Application for a non-material amendment following a grant of planning permission. Town and Country Planning Act 1990

Proposed extension & alterations

H14-0090-21

Job Ref.	Drawing No.
3631-20.	02F.
Date	Drawn
APRIL 2020.	S.L.P.

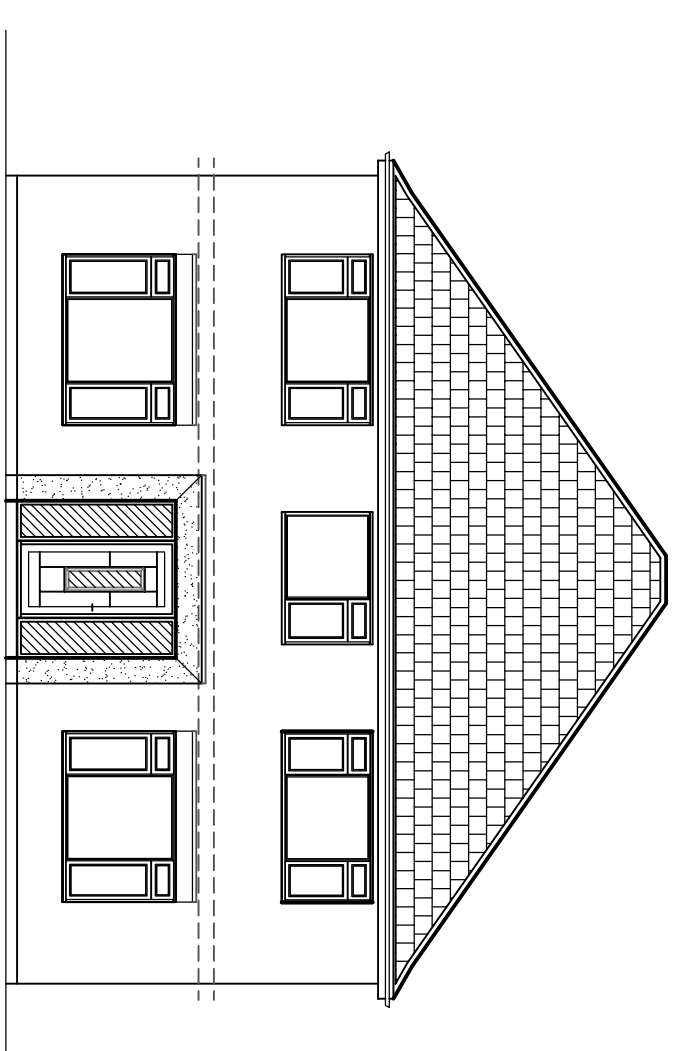
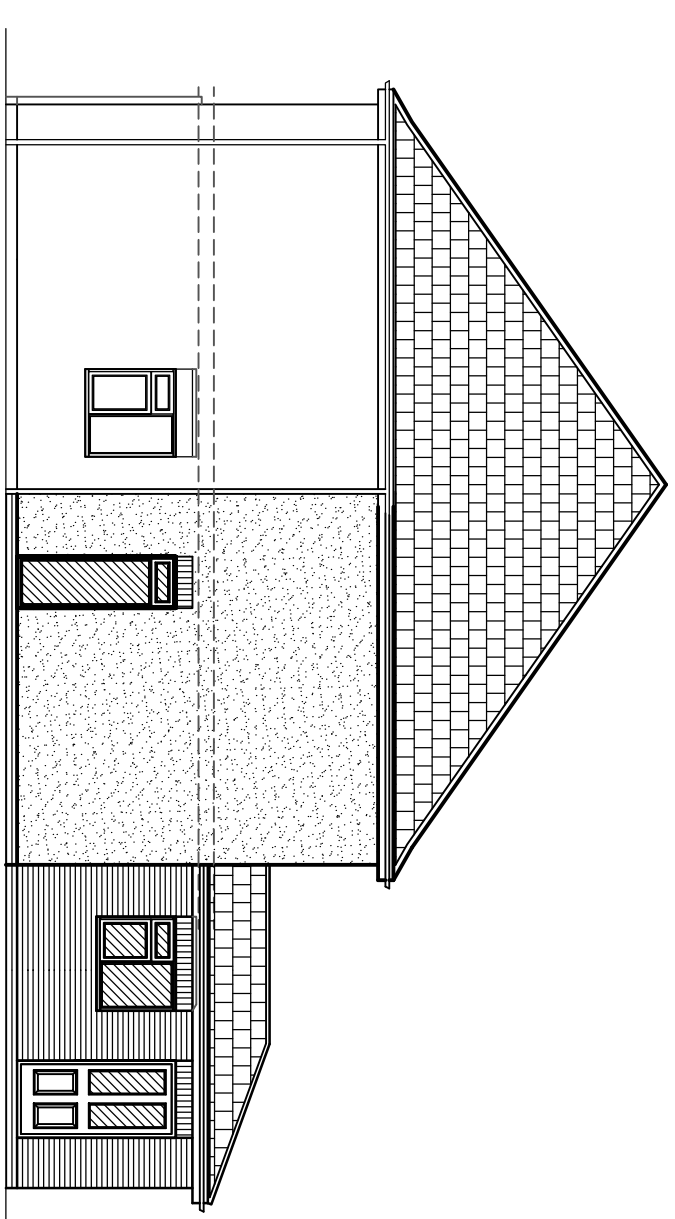
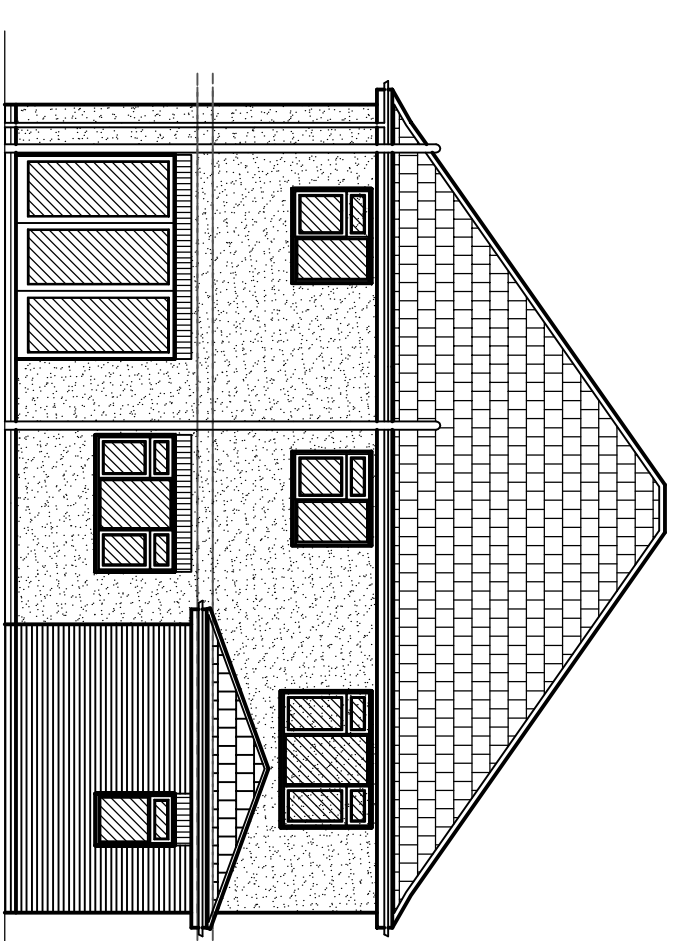
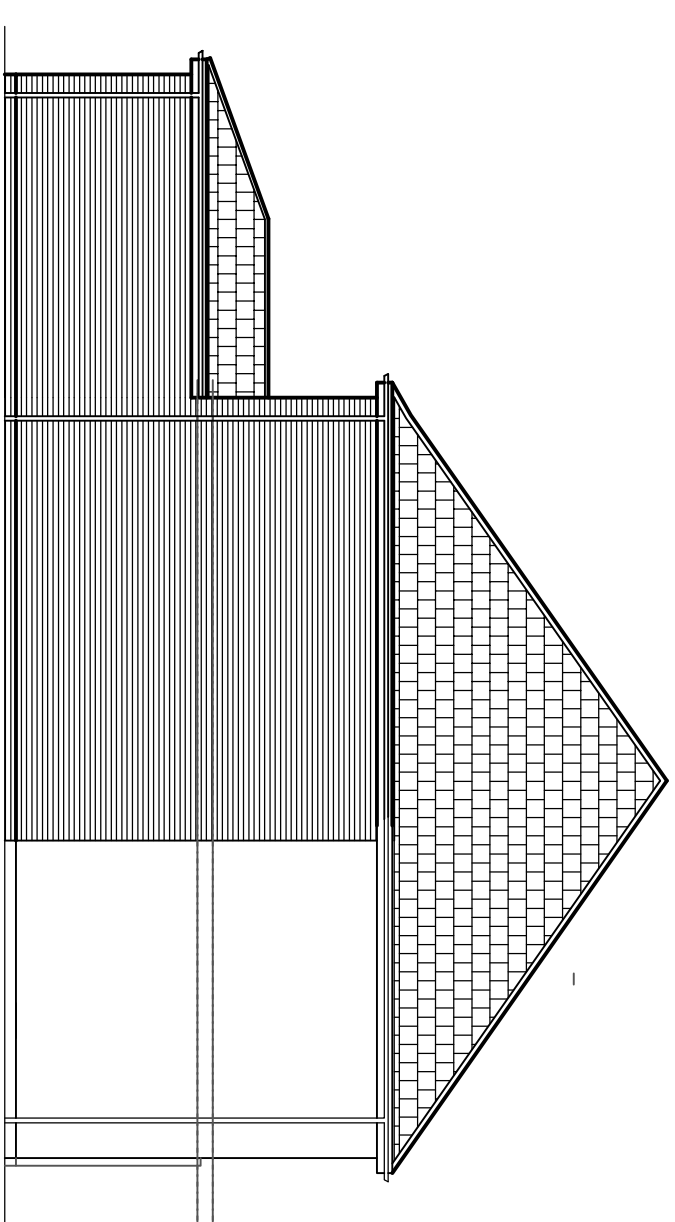
Grey slate tiles to be used and pewter grey render

3631-20-02E

3631-20-02F
